PROPOSED PORT TERMINAL AT
FORMER TILBURY POWER STATION

RESPONSES TO INTERESTED PARTIES' DEADLINE 5
SUBMISSIONS

TILBURY 2 DOCUMENT REF: POTLL/T2/EX/194

Issued for Deadline 6 on 3rd August 2018

REVISED SHEET 3 OF THE WORKS
PLANS

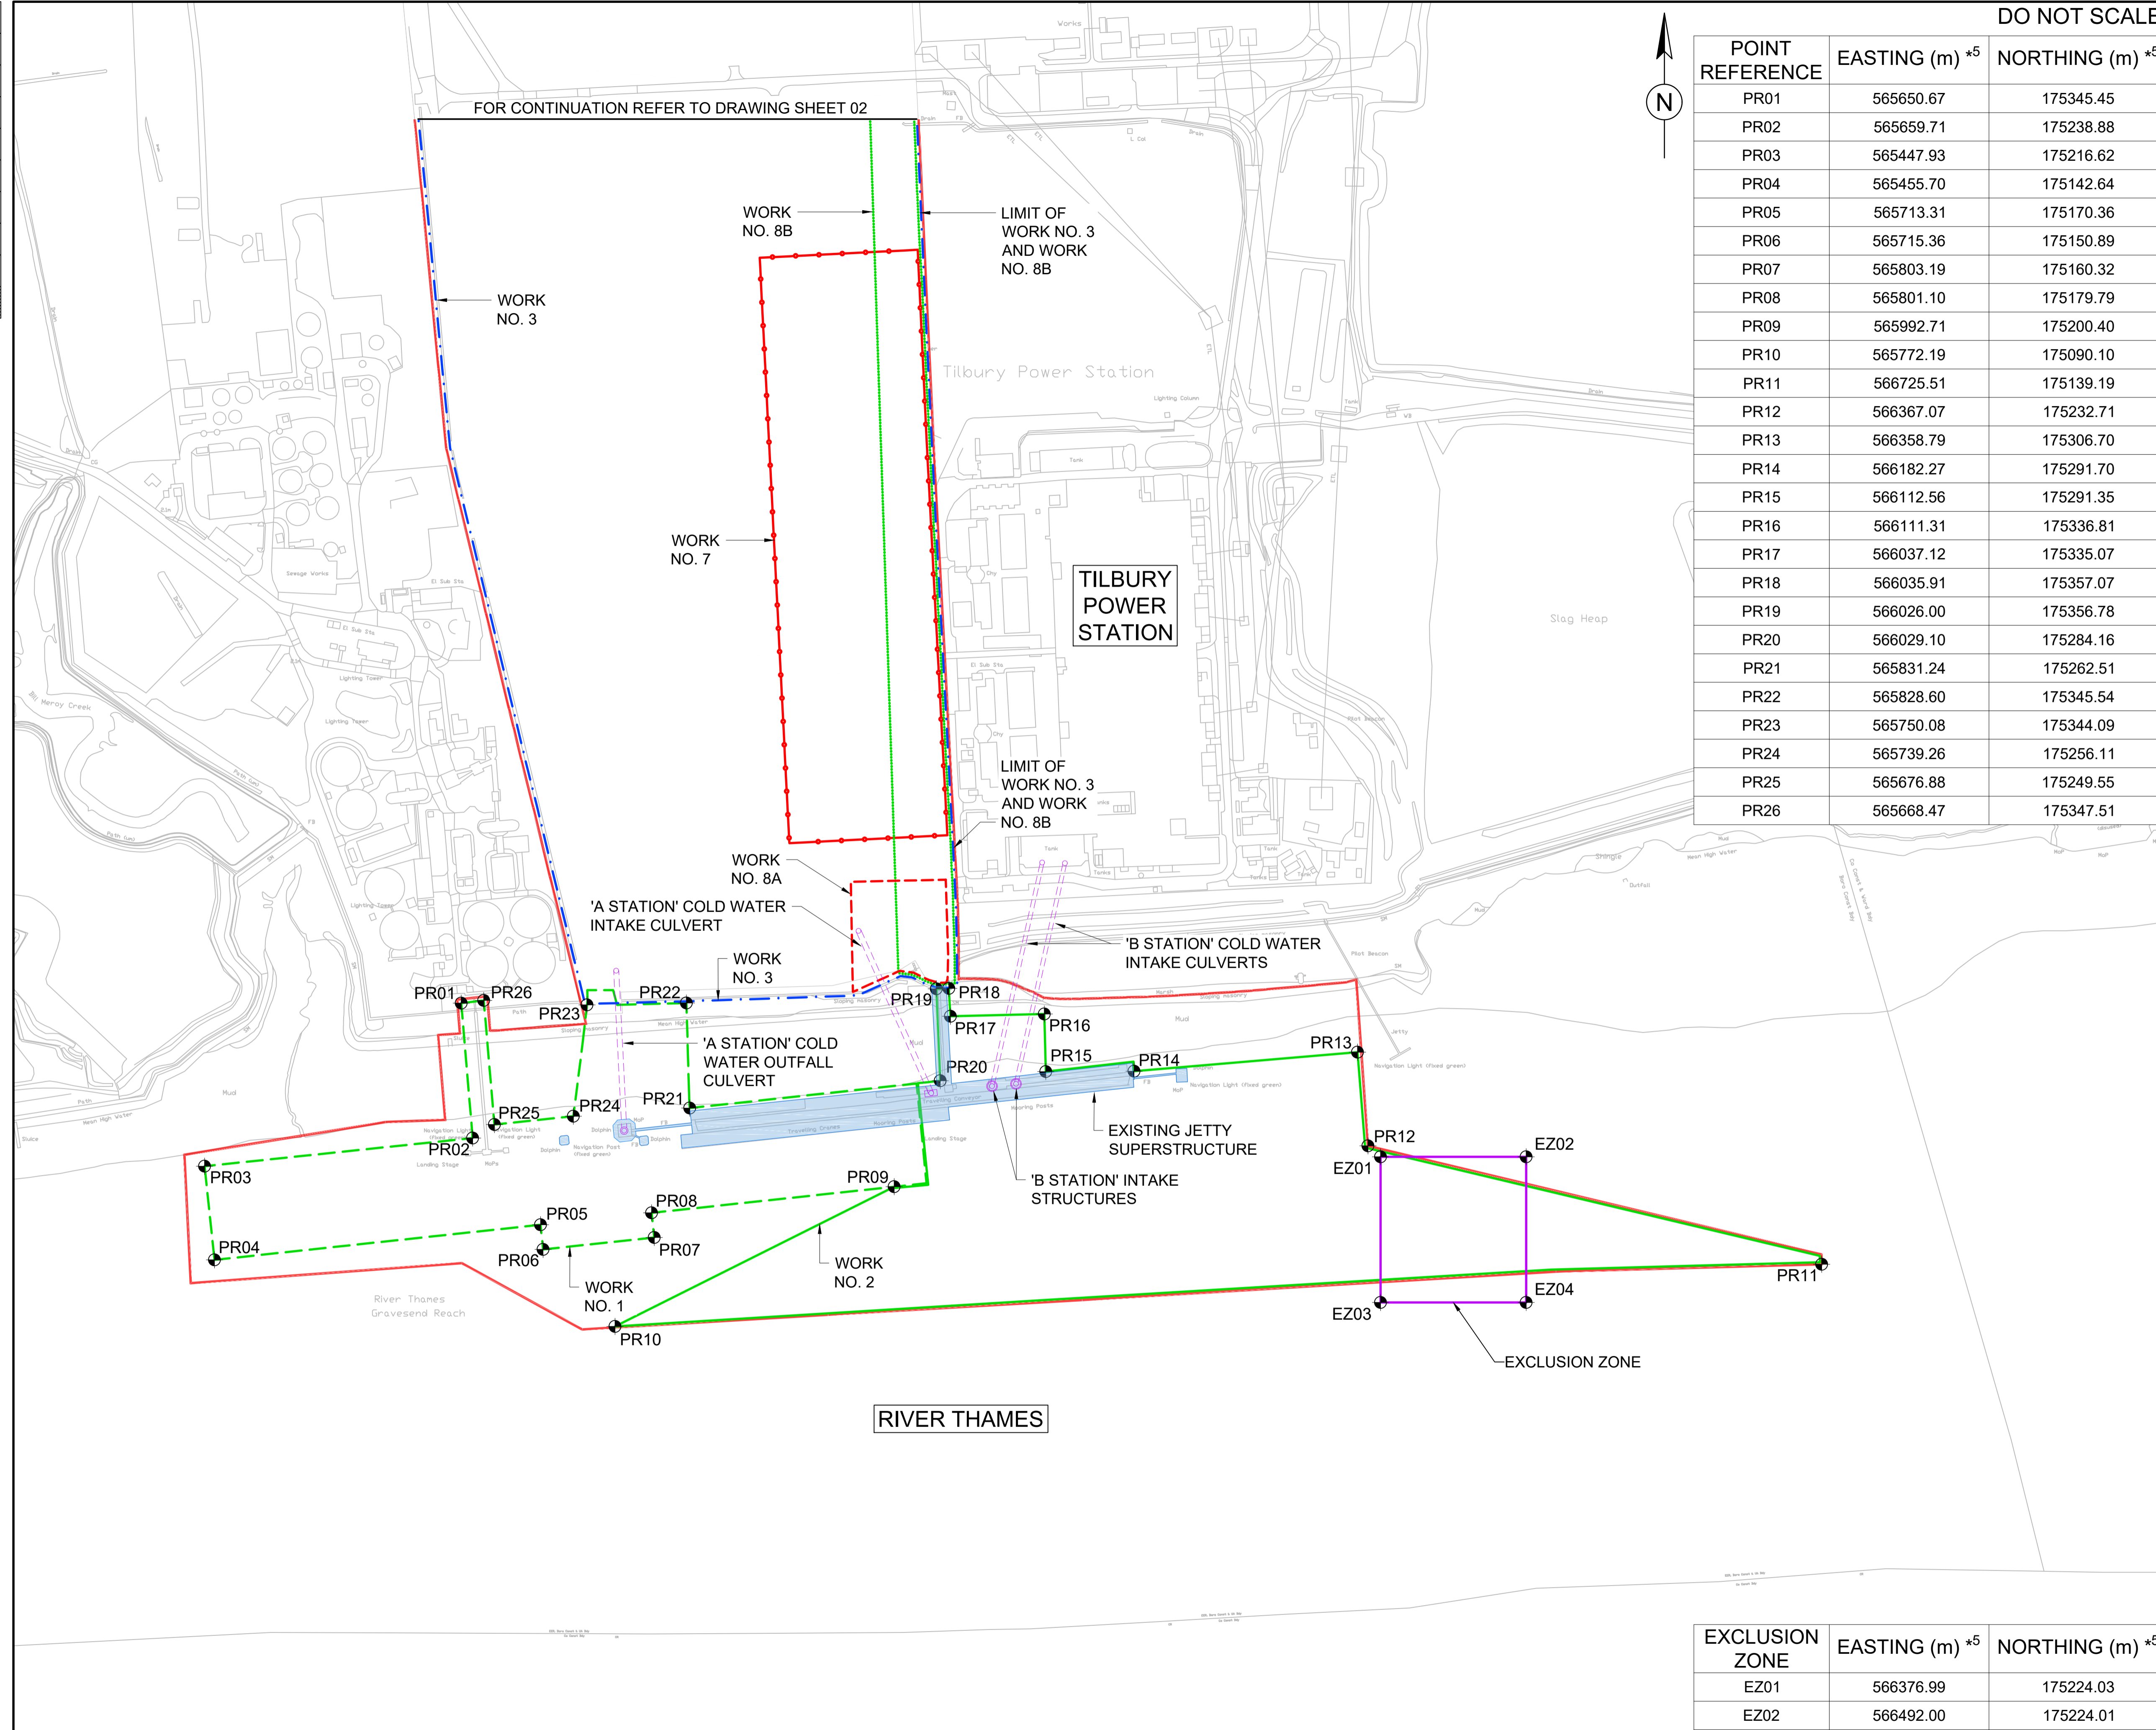
RWE	Paragraph 2.3	Notwithstanding the above, RWE has proposed minor amendments to clarify the extent of the "B station" intake structures, and too make it expressly clear that the jetty superstructure does not include any of the existing 'B station' intake structures, and to clarify that any RWL for the 'B station' intake structures can be terminated in part. The ExA is referred to Annex A of this submission where these proposed changes are highlighted as tracked changes to the current Article 3	These amends have been incorporated in the DCO submitted at Deadline 5.
RWE	Paragraph 2.5	Removal of the words within the definition of 'alternative apparatus' avoids the identification of an area within the extended port limits within which RWE could place alternative apparatus and enjoy the benefit of the protection related to it in the protective provision. RWE considers it would be unnecessarily restrictive to its TEC proposals to require it to identify this area at this stage. The absence of such a restriction will not prejudice the Applicant since the Applicant still retains the ability to object to any application for a future RWL (on the basis set out in Article 3) or a future DCO for alternative apparatus. The purpose of paragraphs 9 to 11 of the draft protective provision is to provide certainty for RWE in respect of the construction, use and maintenance of any alternative apparatus, and to provide for the necessary rights to be granted to RWE in the event RWE obtains a licence for alternative apparatus from the PLA without being subject to a landowner ransom from the Applicant.	The inclusion of this zone has been agreed between the parties and is included in the dDCO and Works Plans sheet 3 submitted at Deadline 6.
